Rezoning Transportation Analysis

Petition Number: 2021-160

Date	Description
08-20-2021	First Review (WB)
09-17-2021	Second Review (WB)
10-18-2021	Third Review (WB)

RZ - 2

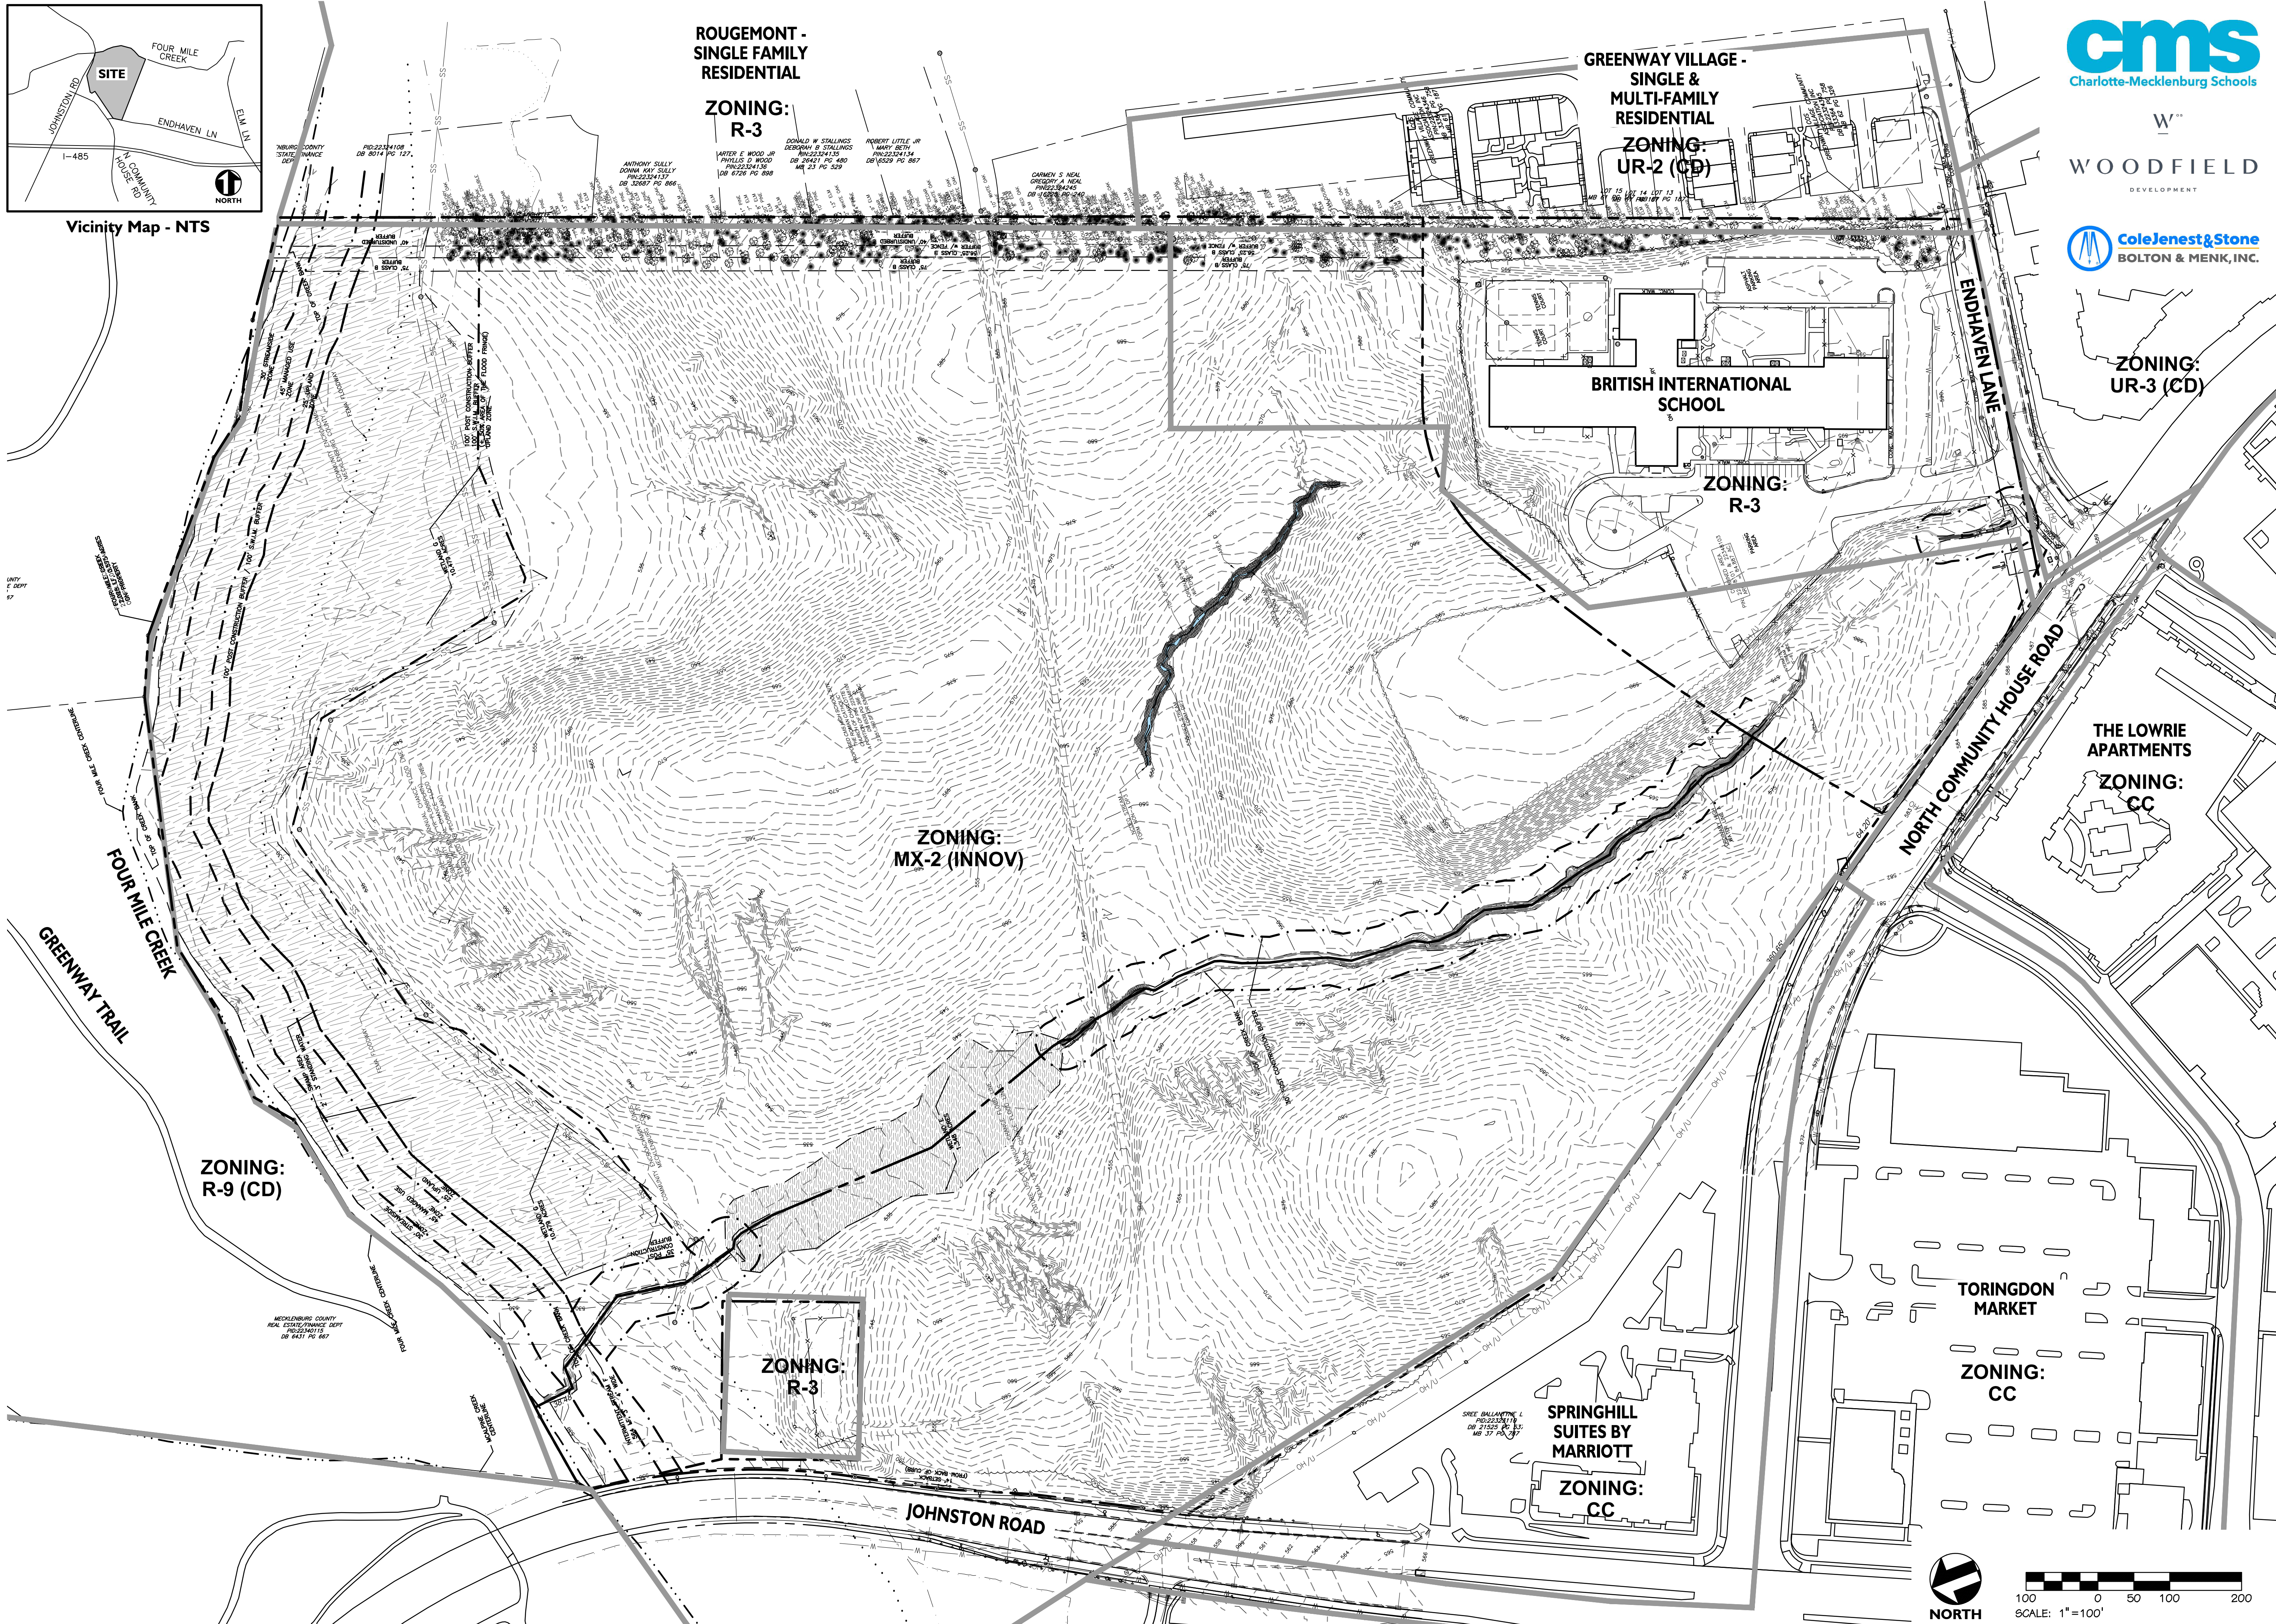
5. **New Comment** (based on Site Plan dated 10-11-2021)
Site plan and conditional note(s) revisions are needed to commit to construct bicycle facilities by installing a 12' multi-use path with an 8' planting strip along the site's Johnston Road frontage to meet the City of Charlotte BIKES Policy.

○ **Local Residential Wide Street**
N.T.S.

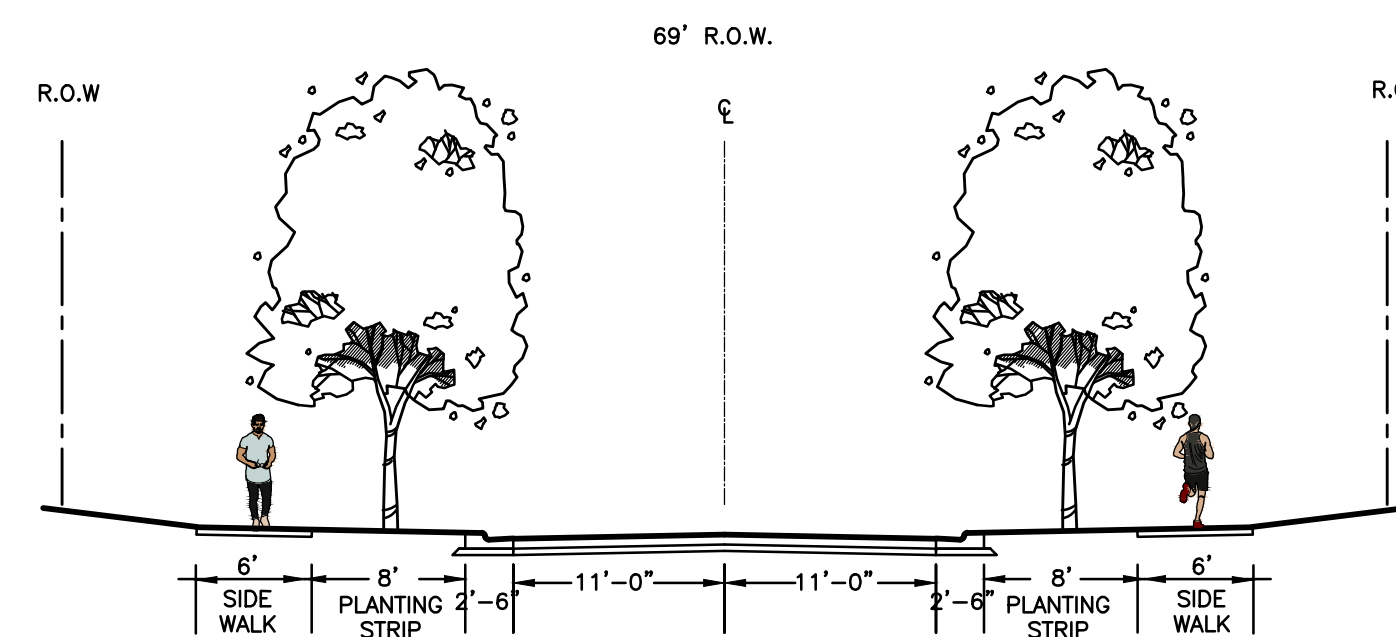
Revise site plan and conditional note(s) to commit to construct an 8-foot planting strip, and 6-foot sidewalk on all proposed public local roads per Chapter 19 and 20 and in accordance with the Charlotte Walks Plan. Accessible curb ramps shall be provided at every intersection per PROWAG and ADA law. The site plan shall label and dimension both items from the back of curb and gutter and road centerline.
